Online Comment

Application H16-1036-15
Location Rear of 34 and 34a Cowbit Road Spalding PE11 2RQ
Proposal Pair of semi detached dwellings

Date Submitted 23-11-15
For/Against Objections

Site Block Plan
1 : 250

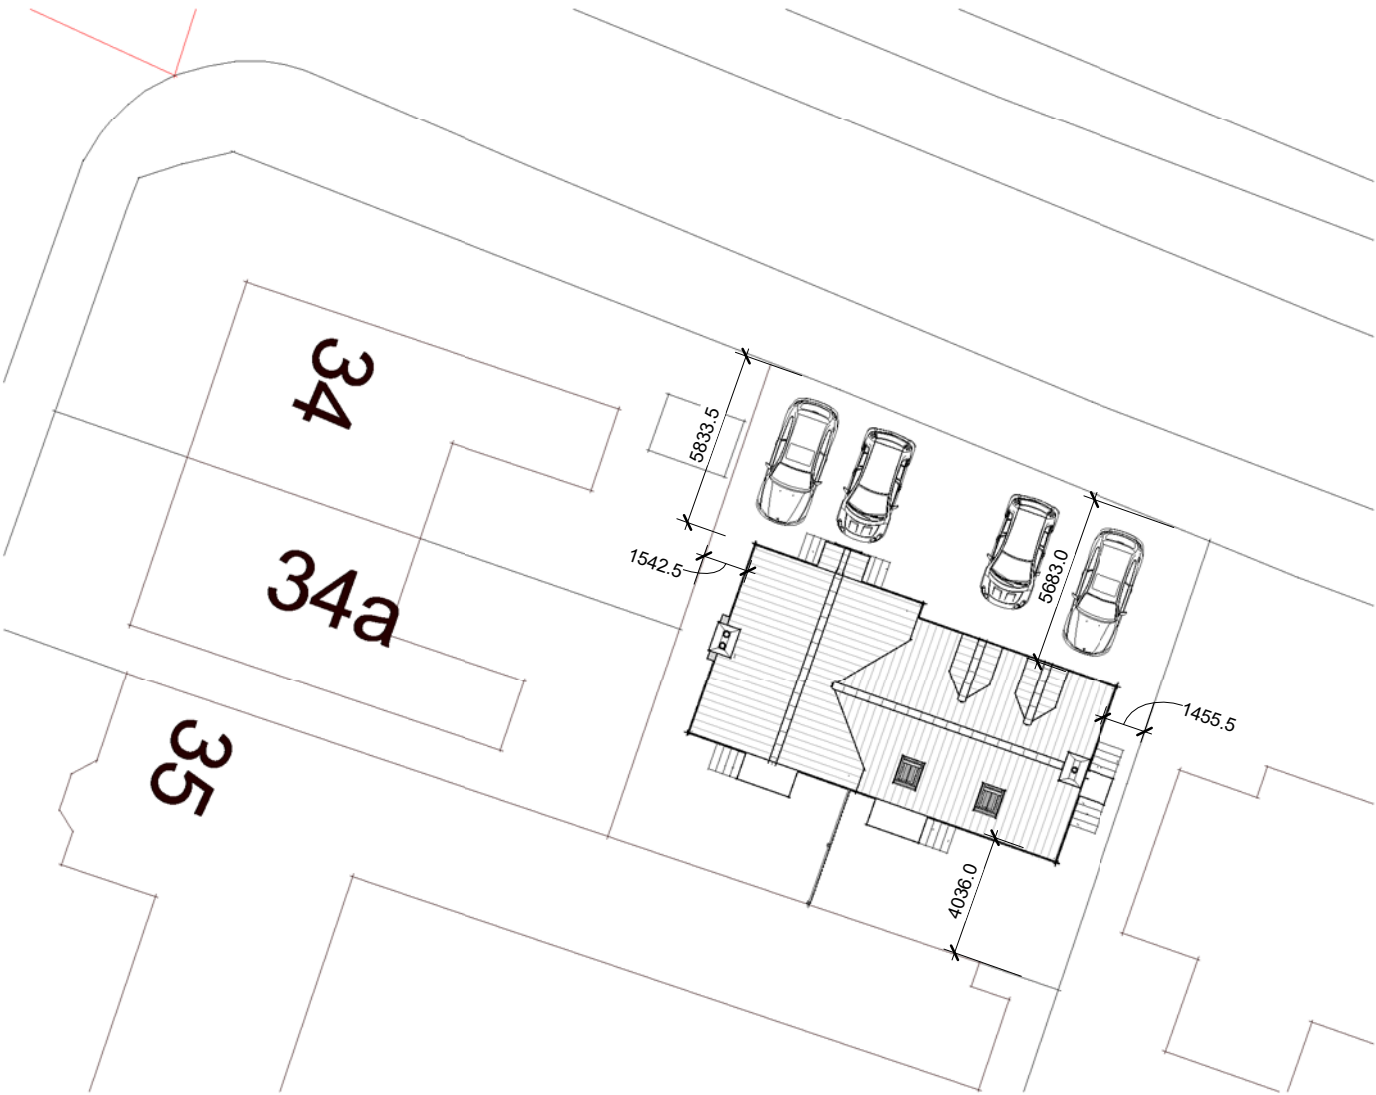
The application form, design and access statement, and plans take no account of the likelihood that residents of these dwellings close to the town centre may be cyclists and will need somewhere to store their cycles. Permission should not be granted unless amended plans are submitted demonstrating satisfactorily how cycles can be stored securely and protected from adverse weather.
